Rezoning Transportation Analysis

Petition Number: 2022-114

Date	Description
12-28-22	First Review (TM)

REZONING PLAN

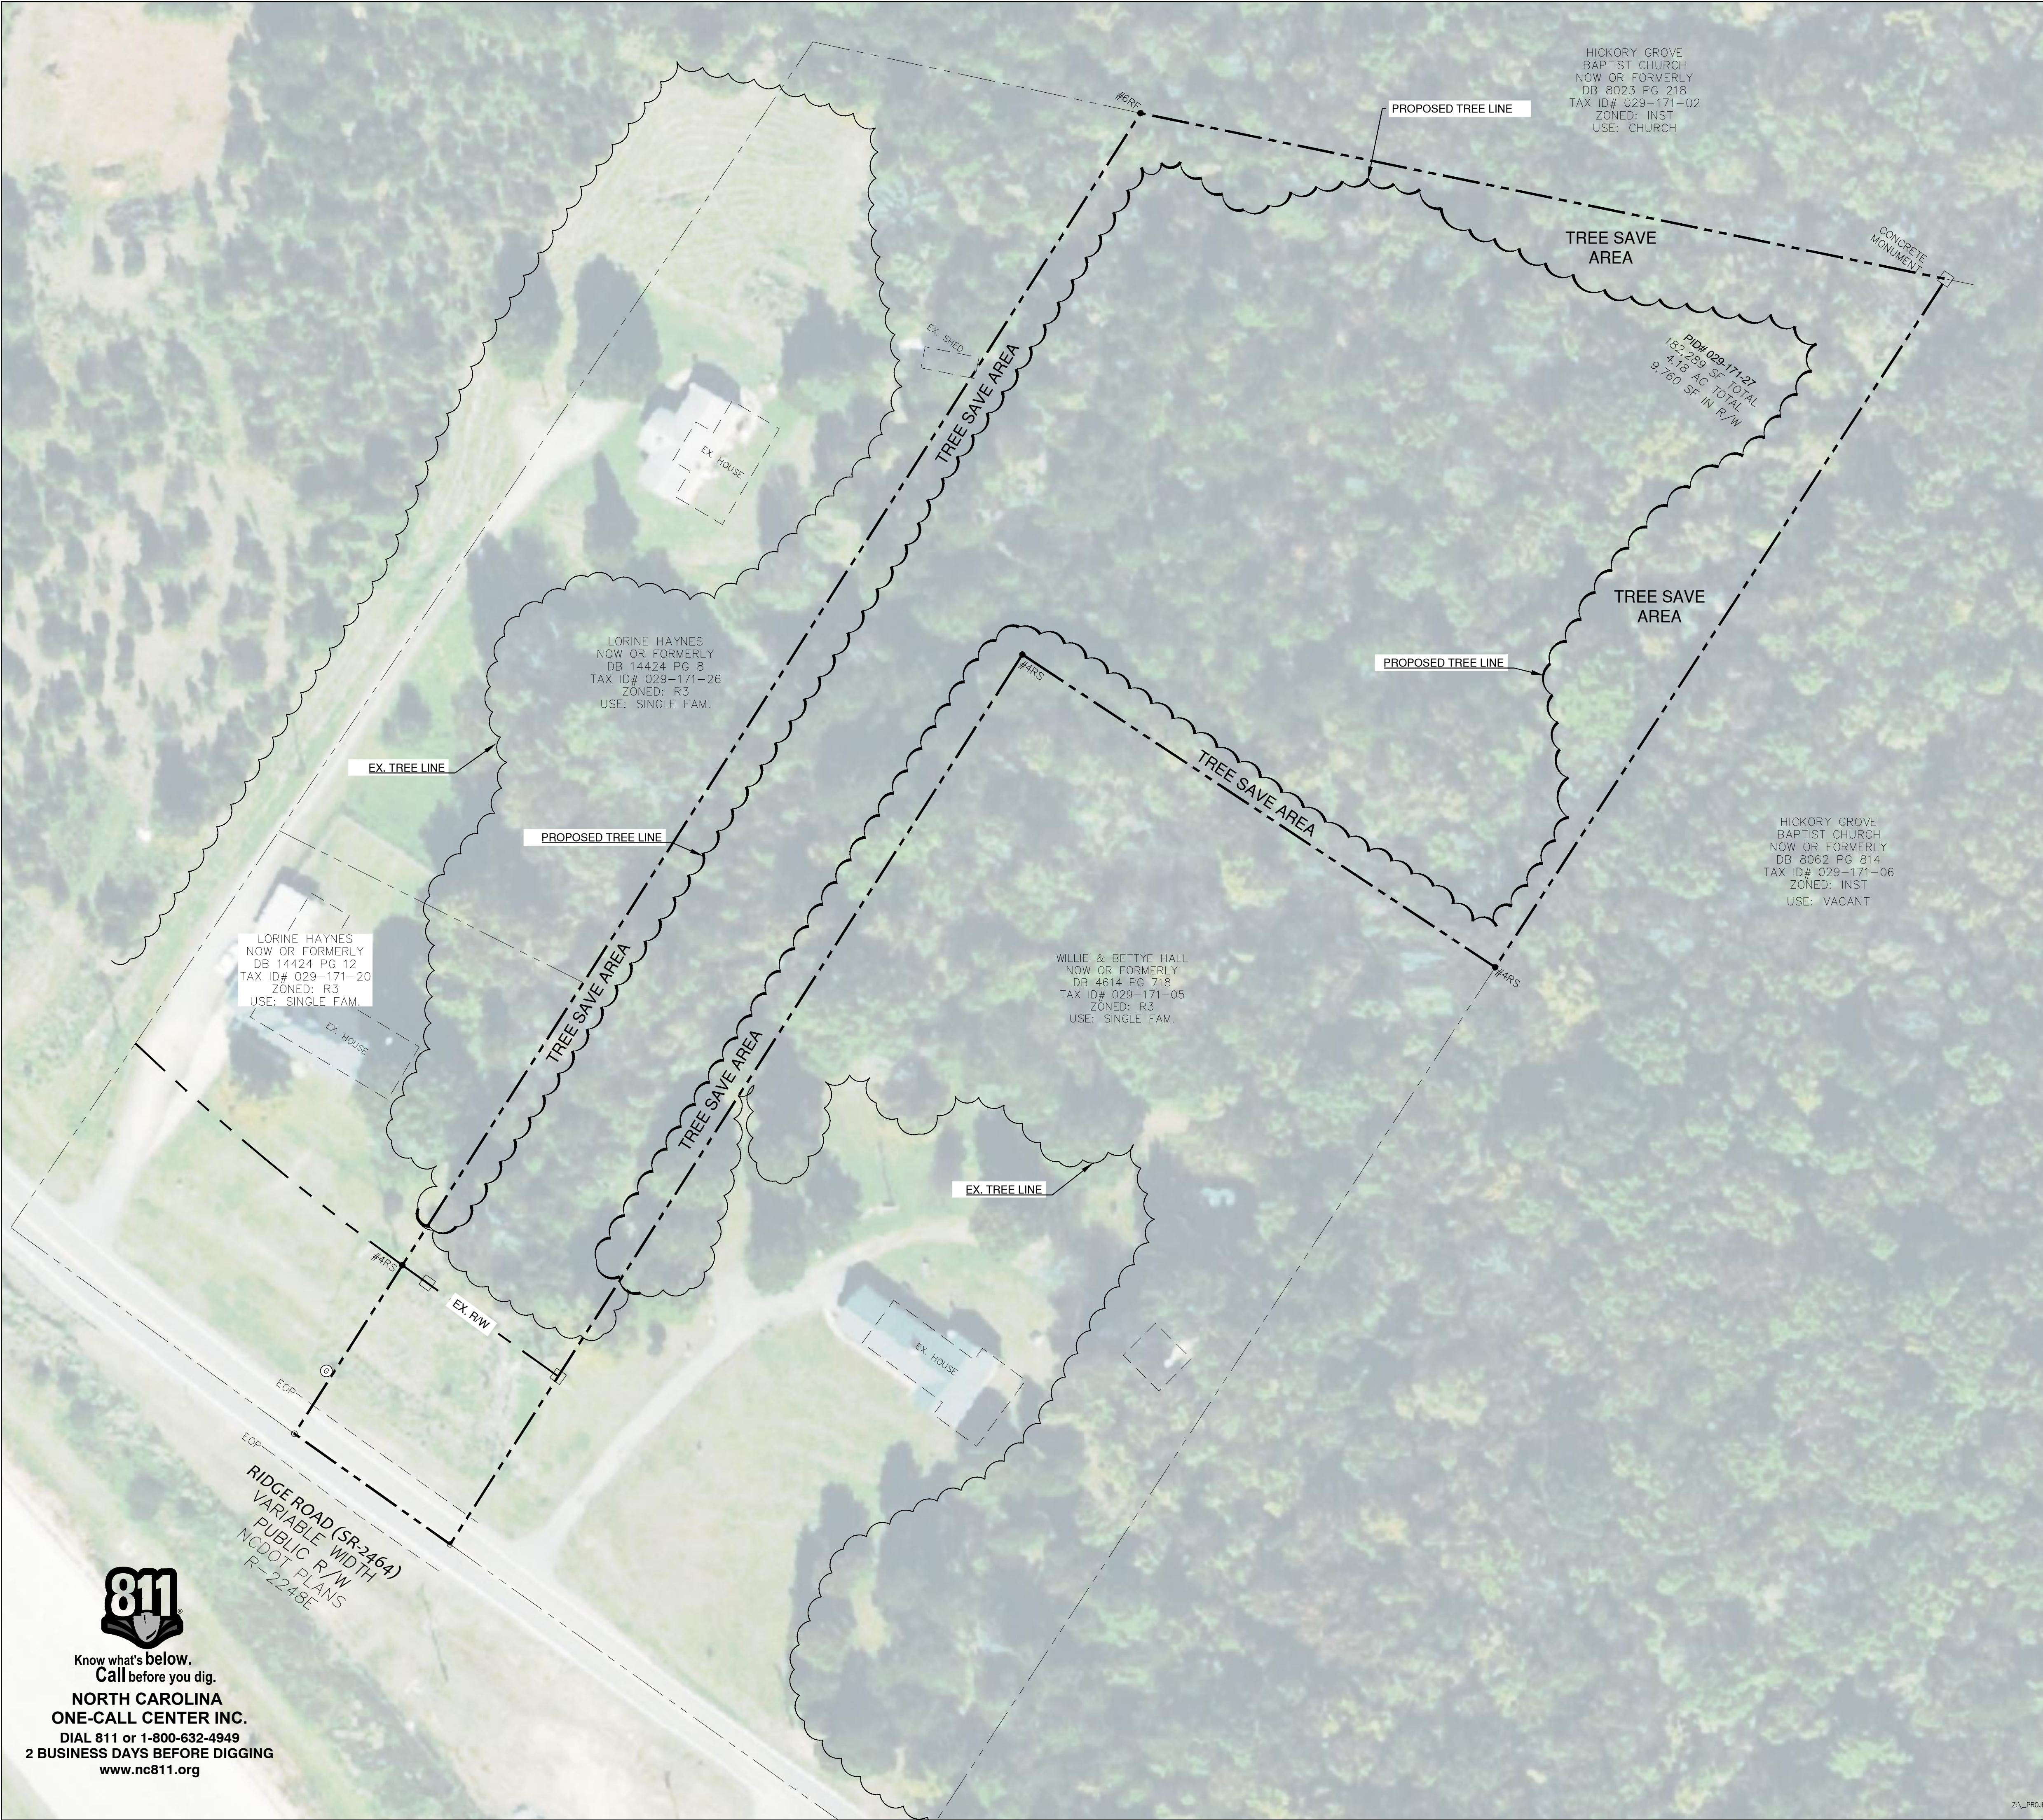
- a. **Ridge Road:** Future back of curb and gutter to be located 30 feet from roadway centerline to accommodate the Charlotte Streets Map with a roadway typical section of CLDSM 11.09 Major Thoroughfare.

Label and dimension the future curb and gutter from the centerline for each road on the site plan.

3. Revise site plan and conditional note(s) to commit to dedicate 50 right-of-way from the road centerline. The site plan shall label and dimension the right-of-way from the road centerline.

4. Revise site plan and conditional note(s) to commit to constructing the proposed private road as a public roadway meeting CLDSM U-02 to be dedicated from Ridge Road to the internal site connection. Right-of-way should be dedicated to the property line along this public roadway to provide future access to adjacent parcels.

5. Revise site plan and conditional note(s) to commit to construct an 8-foot planting strip, and 6-foot sidewalk on all internal public roads per Chapter 19. The site plan shall label and dimension both items from the back of curb and gutter or edge of pavement.

6. Revise site plan and conditional note(s) to commit to construct bicycle facilities by locating the curb and gutter 30' from the center line/installing a 12' multi-use path 8' behind the back of curb to meet the Council-adopted Charlotte BIKES Policy. Multi-use path shall meet ADA/PROWAG requirements.

8. Revise site plan and conditional note(s) to commit to constructing standard 2-foot 6-inch curb and gutter across the entire frontage of the site.
9. Add a conditional note specifying “the Petitioner shall dedicate and convey in fee simple all rights-of-way to the City before the site’s first building certificate of occupancy is issued. CDOT requests rights-of-way set at 2’ behind back of sidewalk where feasible.”
